Subject: Submission re: SSD 8183 (Beryl Solar Farm, Gulgong)

Proponent: First Solar (Aust.) P/L

**Site Development Plan**

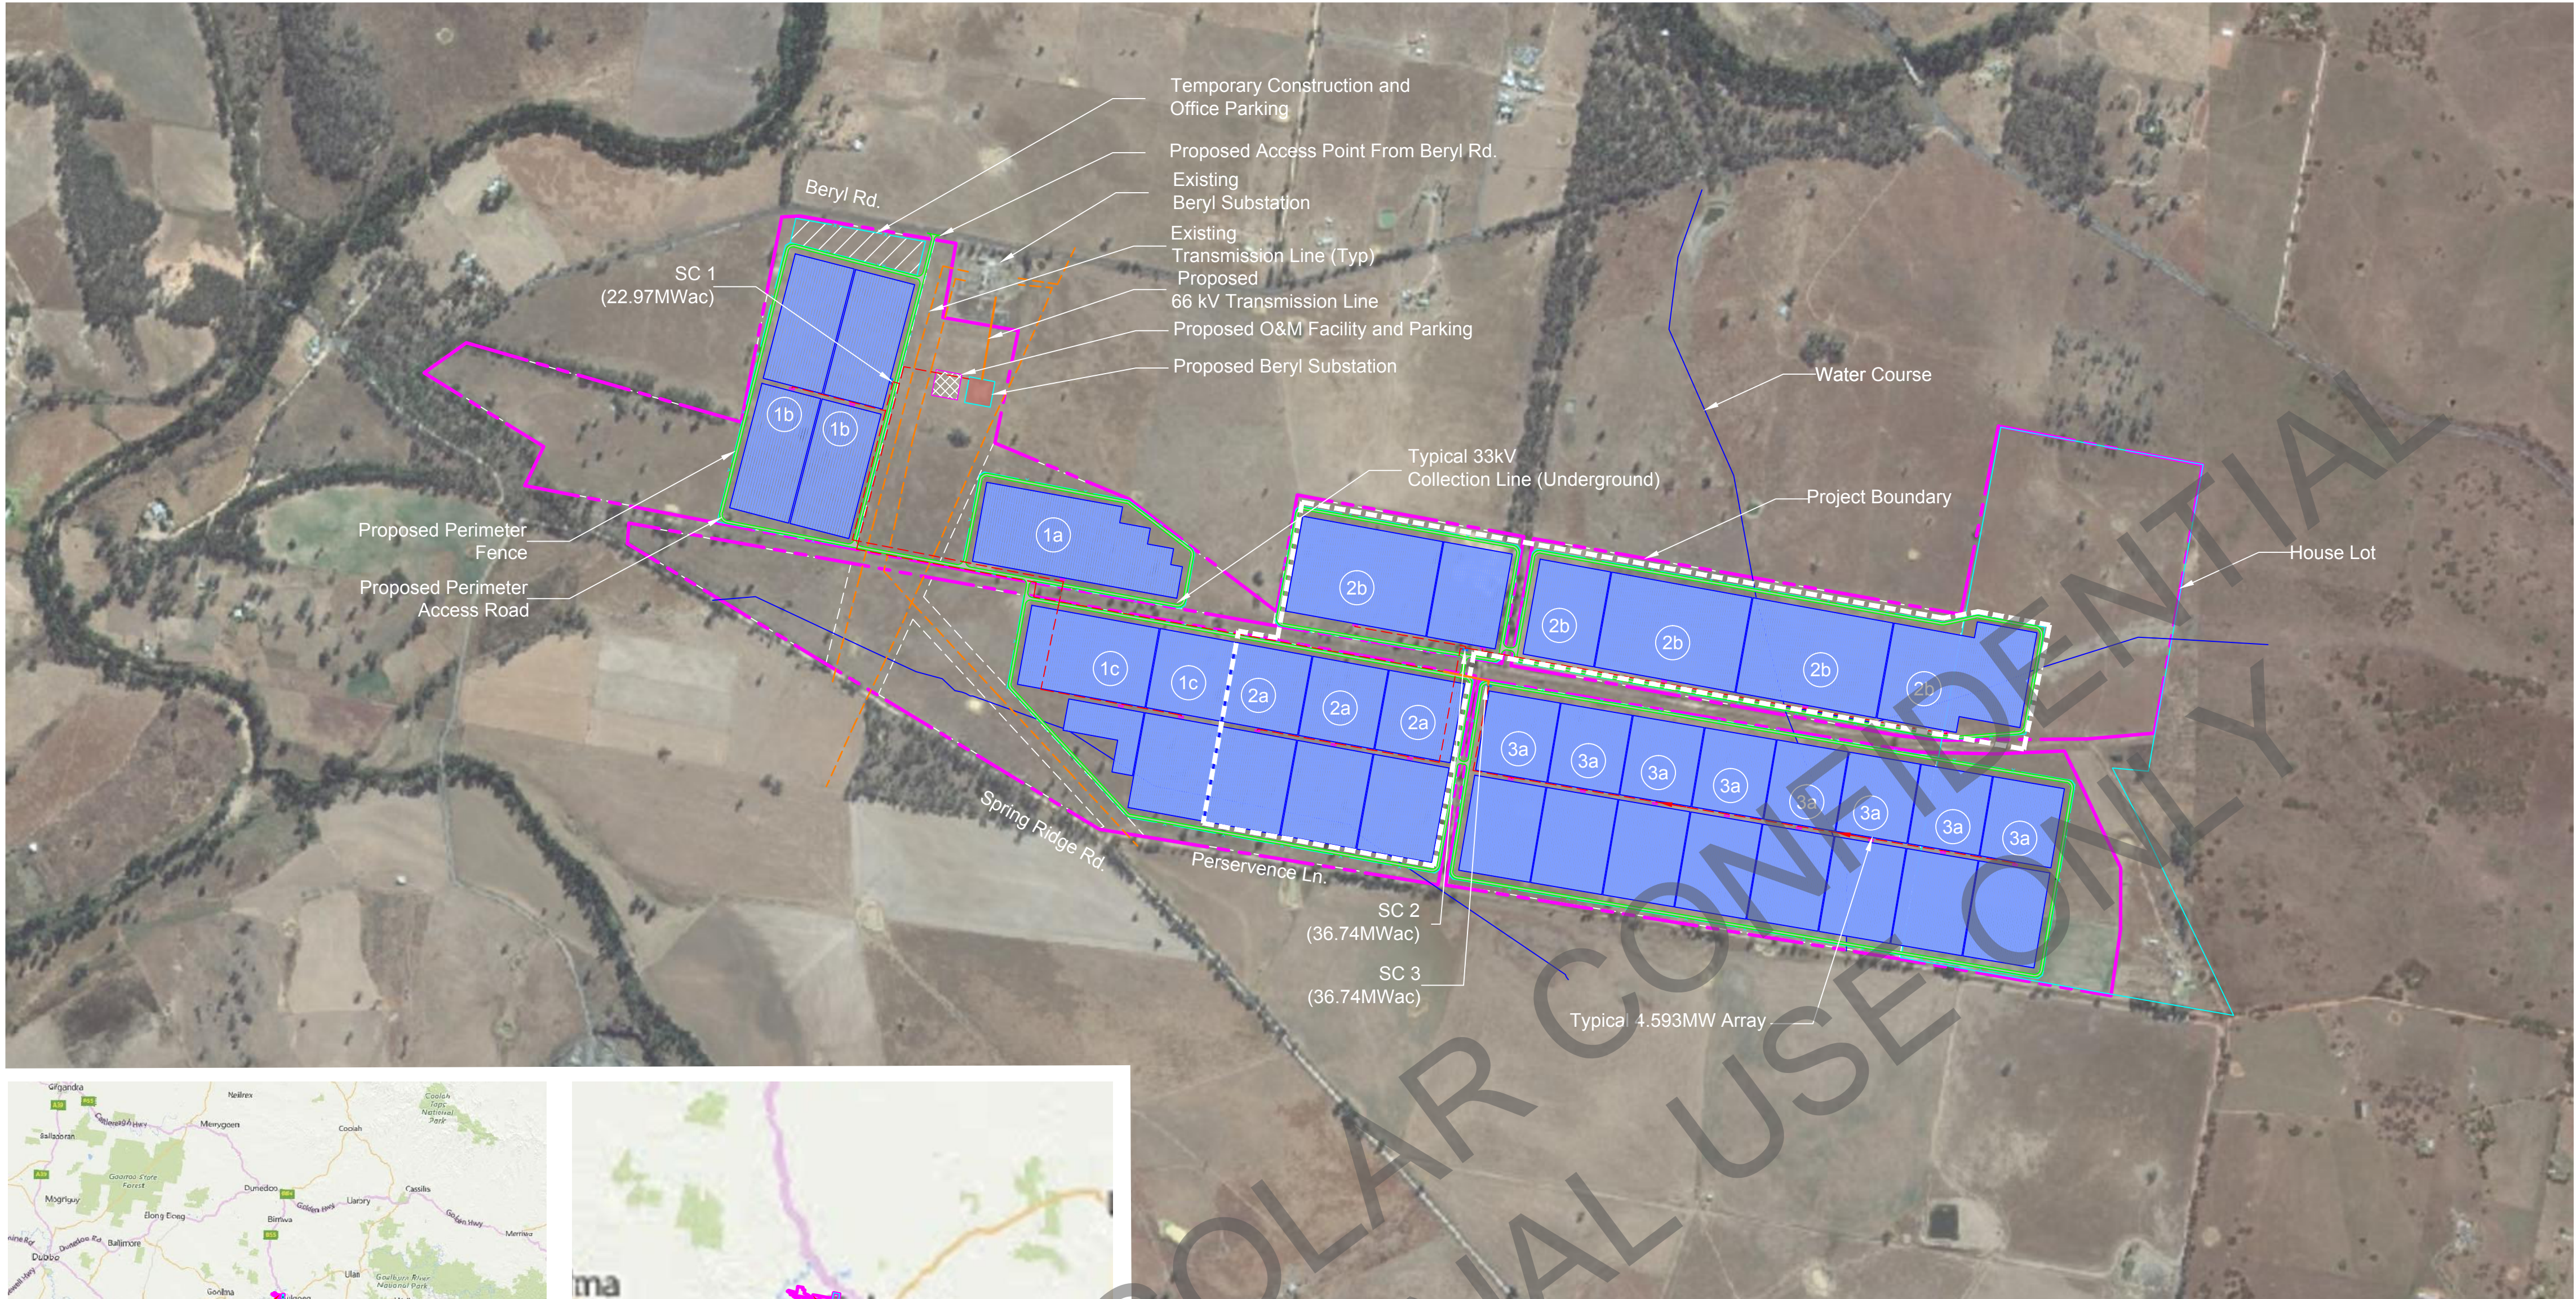
It is also noted that no proposed screening has been included in the application (as depicted Figure 6.1 pg. 67) for the boundaries of several R5 zoned properties including Lot 59. Further that the application states that "where practicable" the infrastructure will be coloured eucalypt green, beige or brown. When asked the specific question as to the colour of the forty containers housing the inverters we were advised that they would actually be white.

Visual Impact: Beryl Solar Farm to Approved Development Lot 59 DP 755434

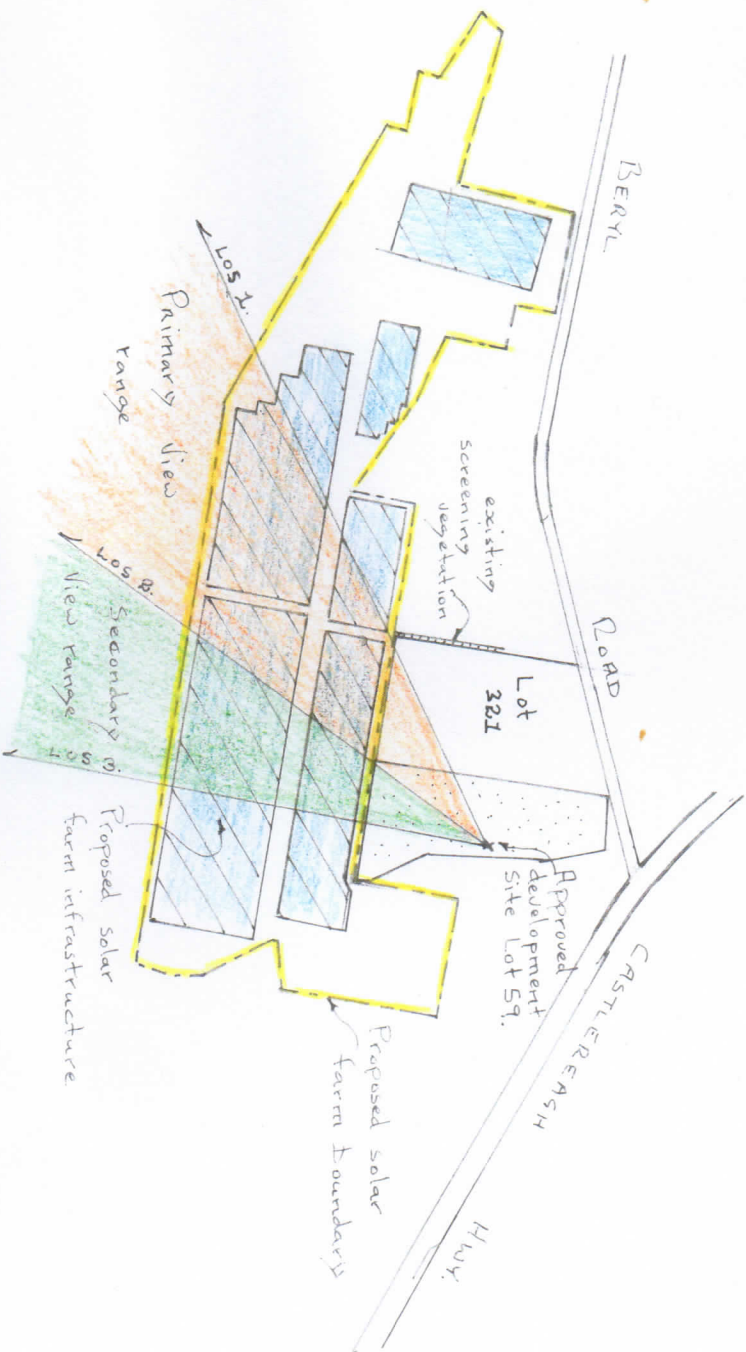
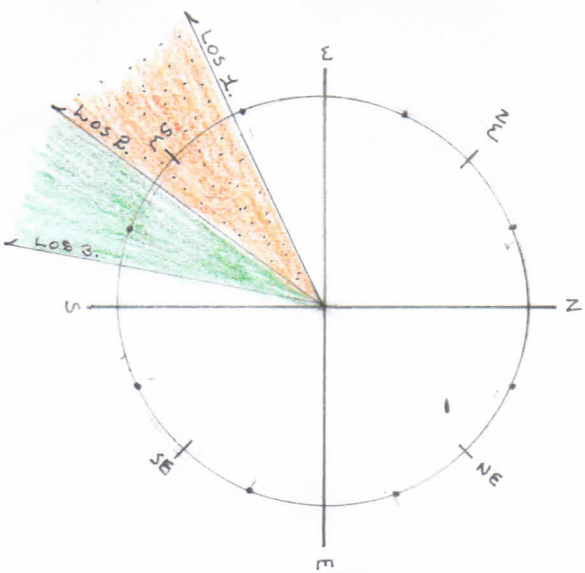
2. **Visual Impacts:** That the Application fails to adequately identify and address the visual impact issues caused by the development, especially those specific to Lot 59 DP 755434 and the approved development contained thereon.

Rationale: The Visual Impact Report (VIR) describes the site area to be flat or gently undulating but does not compare the site contours in relation to the adjoining Lot 59, where, by falling to the west and rising to the east will exacerbate the negative visual effects from the approved house site. Please see accompanying photos and sketch showing the actual current view and sketch showing the potential effect. The VIR gives all affected dwellings a "moderate" rating as none listed are in an elevated position. As over 90% of the proposed SF infrastructure will be visible from Lot 59 this site must be considered to be a "Very High" visual impact rating. Whilst the proponent will "work with affected landowners" the screening proposed (sparsely planted with species selected to consider shading effects on the panels) will not mitigate the issue given the actual height difference between the SF infrastructure and the approved building site (on Lot 59) **See attachments 1 & 2**
